Planning Officer: David Spring

Planning Application Ref: Y/121/19/PL

Location: The Steddles, North End Road, Yapton, BN18 0DT

Description of works: Demolition of existing dwelling & outbuildings & erection of 11no. dwellings (net increase 10 units), access, landscaping & associated works

N
 Drawing Title:
 Tree Constraints Plan

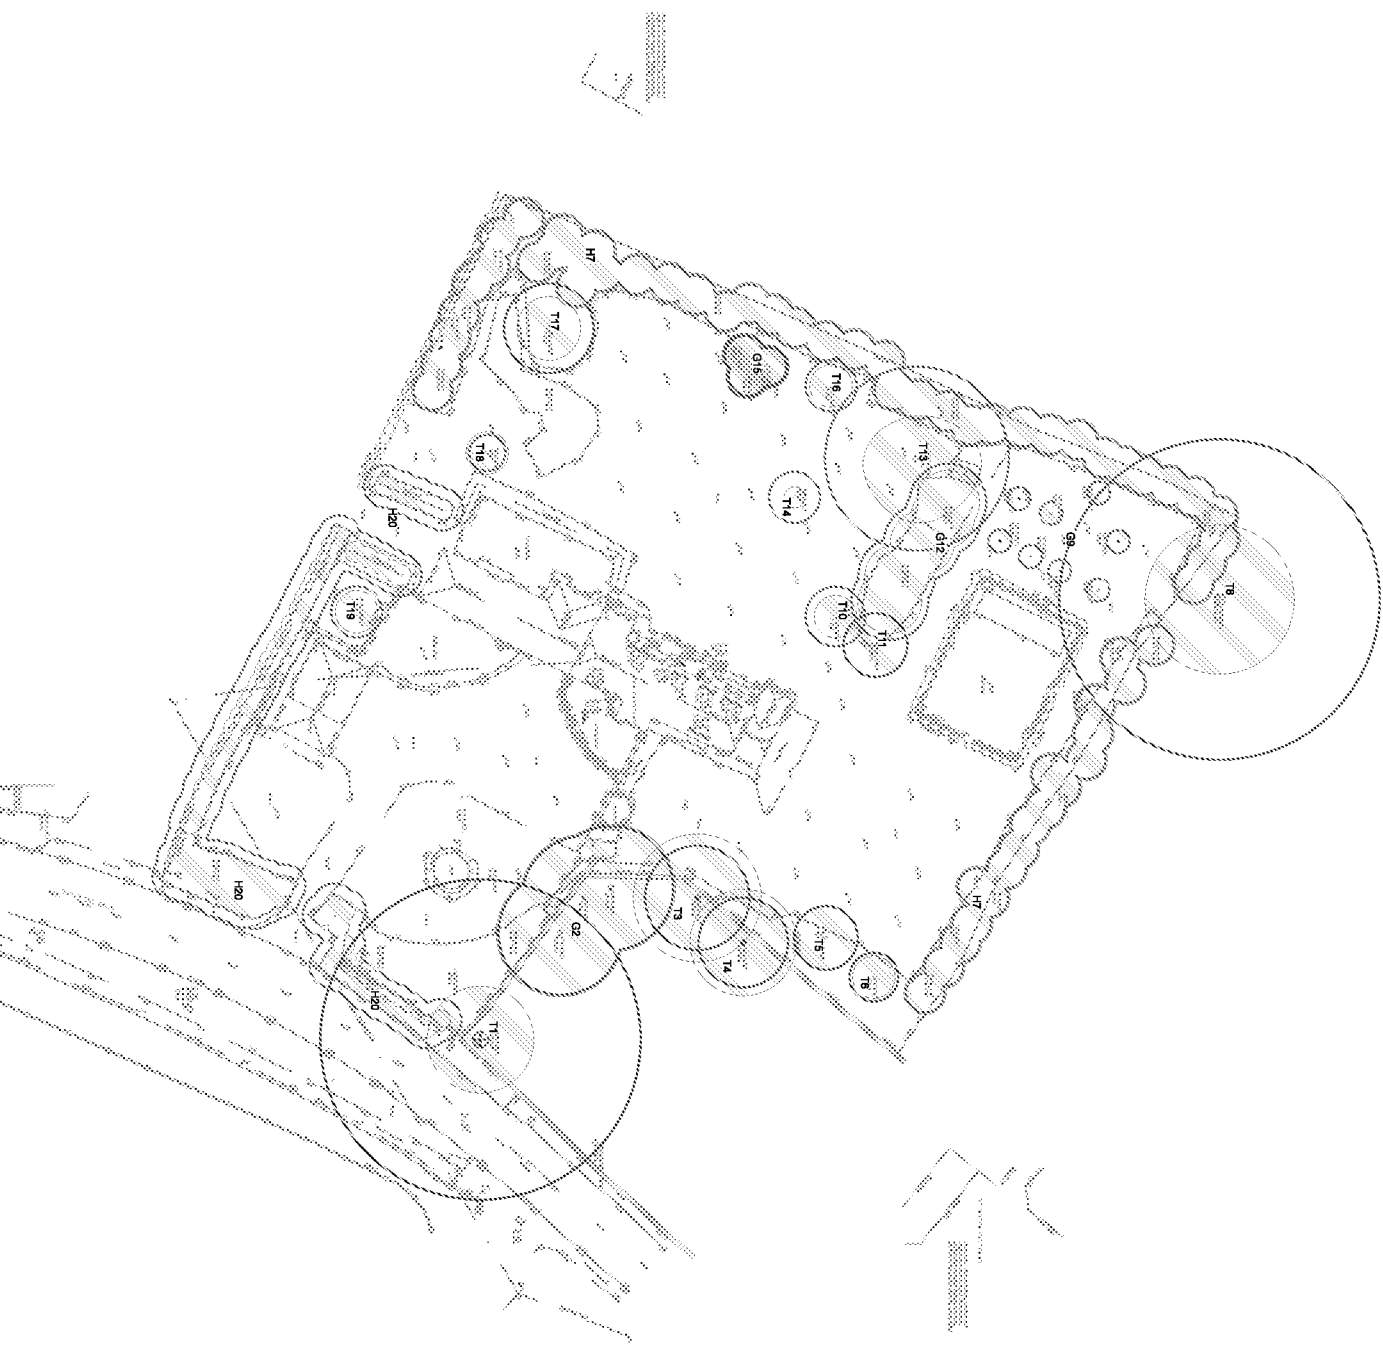
- The arboricultural consultant states concern for the risk of harm to persons or property arising from the poor condition of off-site tree - T1 holm oak. He has applied a Category U rating, which in this context means it is at best unviable for safe long-term retention. I would support his recommendation that the landowner be made aware of such concern, so that a more detailed investigation can be undertaken and appropriate action in good time, to mitigate any unreasonable level of risk.

- I also concur with his view that the nominal root protection area (RPA) of T1 as shown, demands an excessive area of soil volume necessary to ensure its ongoing health and vitality, although I welcome the proposed supervision (by the project arboriculturist) of driveway works within the same (see above AIA & MS).

CLIENT
Elberry Properties
DRAWING TITLE
Retention & Protection Plan

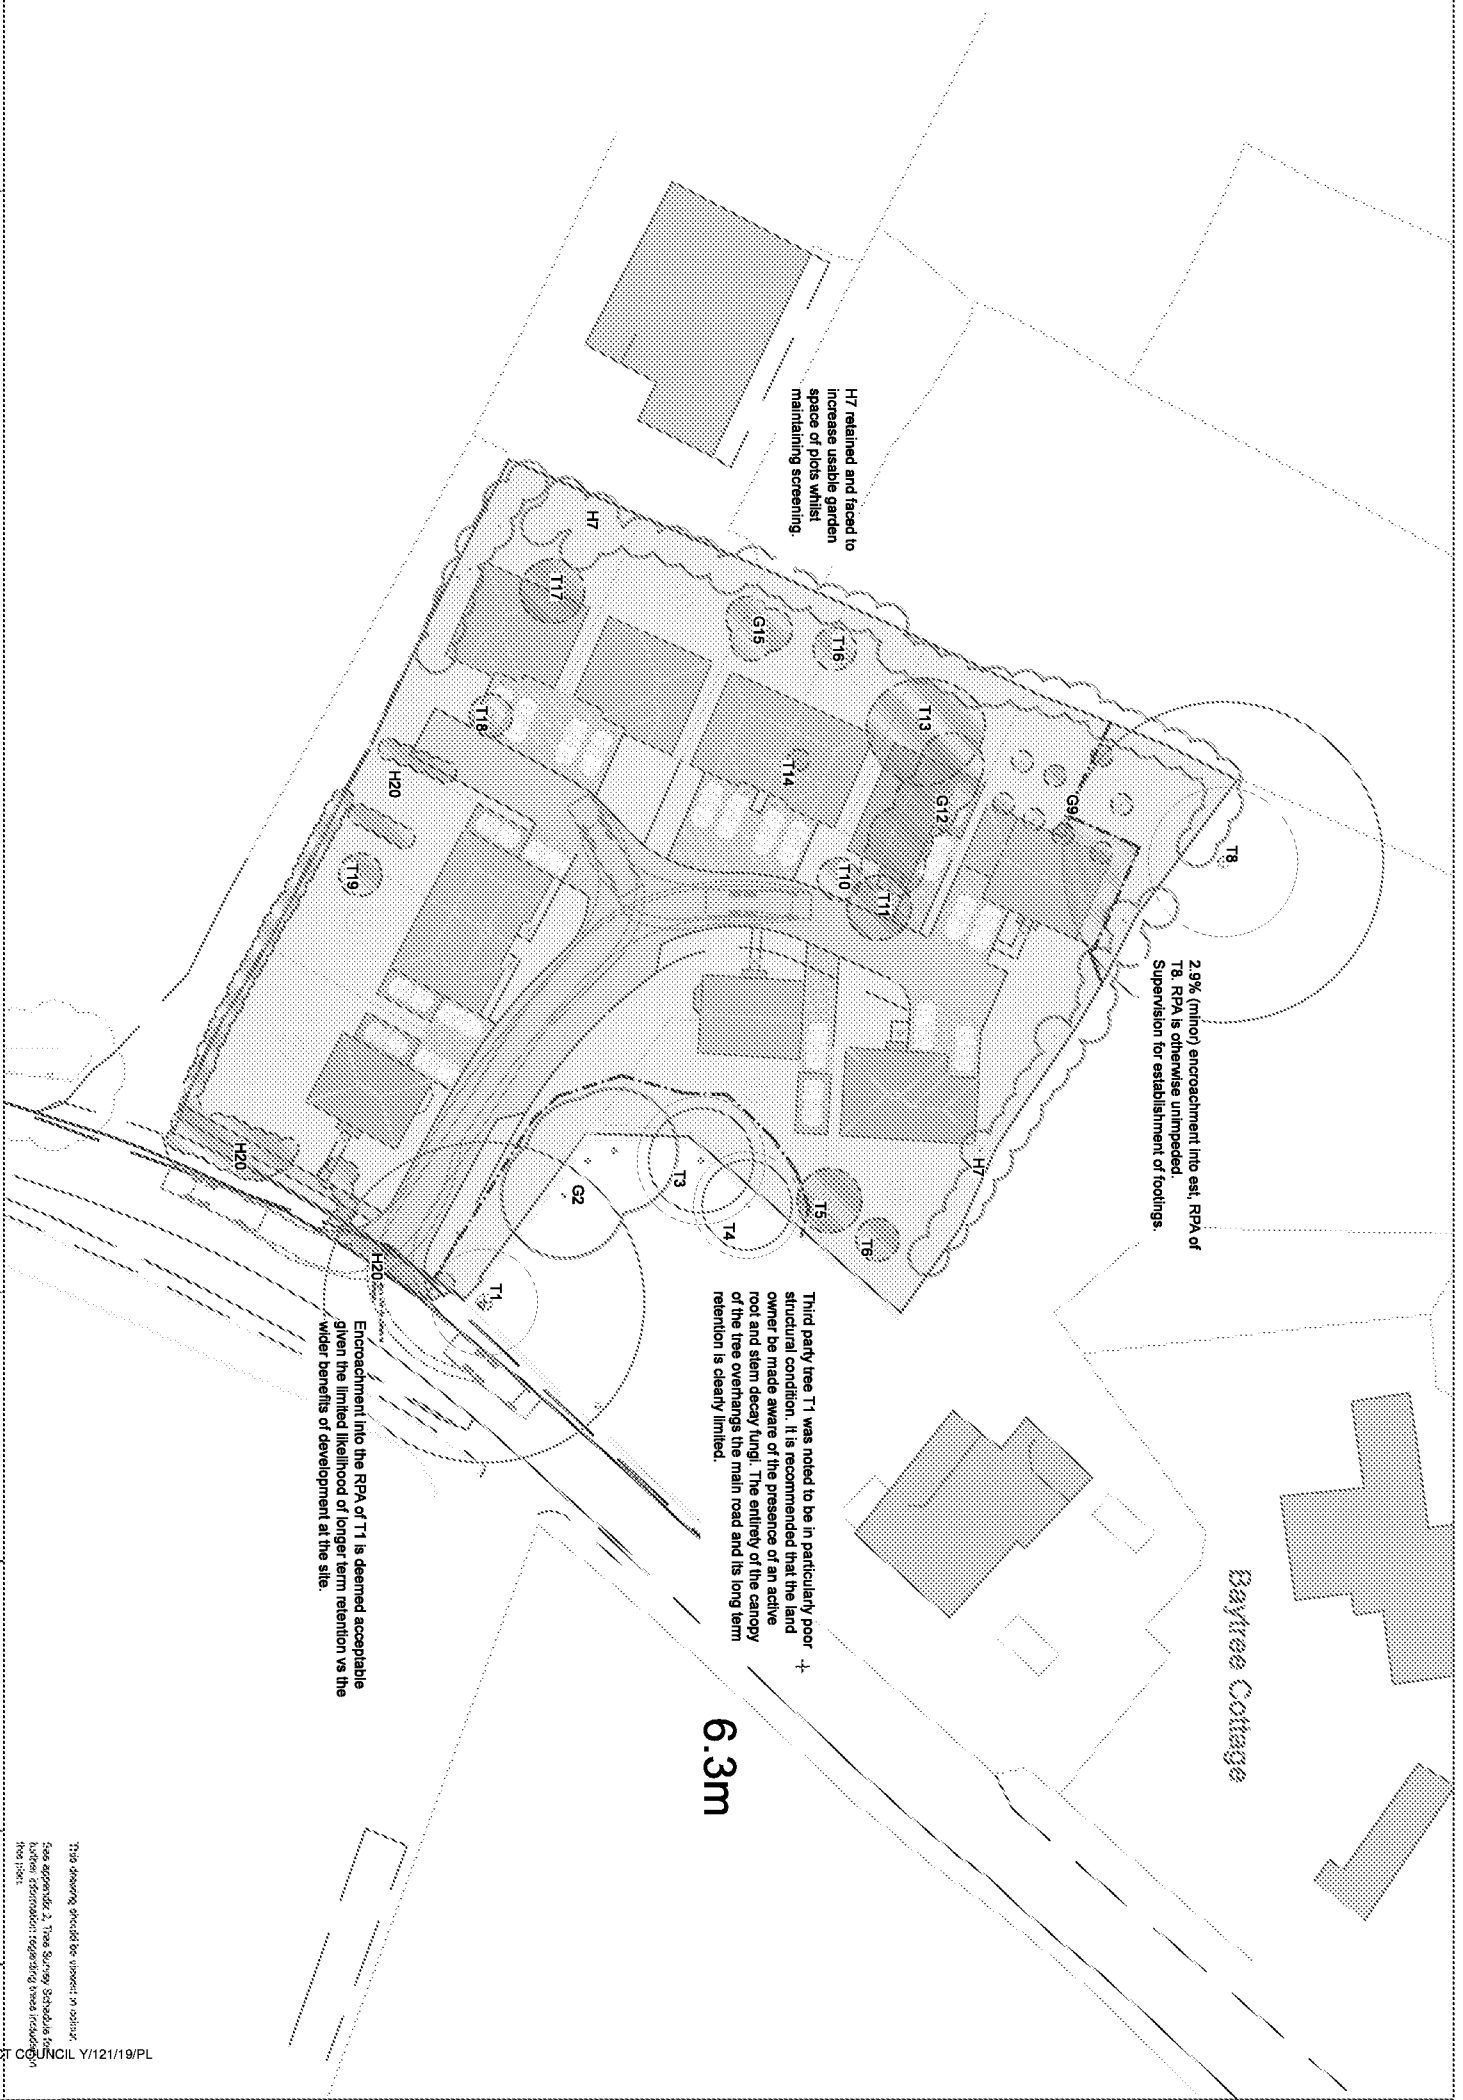
1. Before the site is occupied or any machinery is introduced to the site or demolition work or construction work or alterations to existing ground levels takes place a **PRE-COMMENCEMENT Site Meeting** is to take place between the Planning Authority's Tree Officer and the Arboricultural Expert or other designated competent person representing the site owner(s) – at this meeting all protective fencing and ground protection measures will be inspected to verify they are 'Fit for Purpose' as required under British Standard 5837:2012 and have been erected and positioned exactly as shown on the **(Tree) Retention and Protection Plan, dwg. no. 1892-02.**
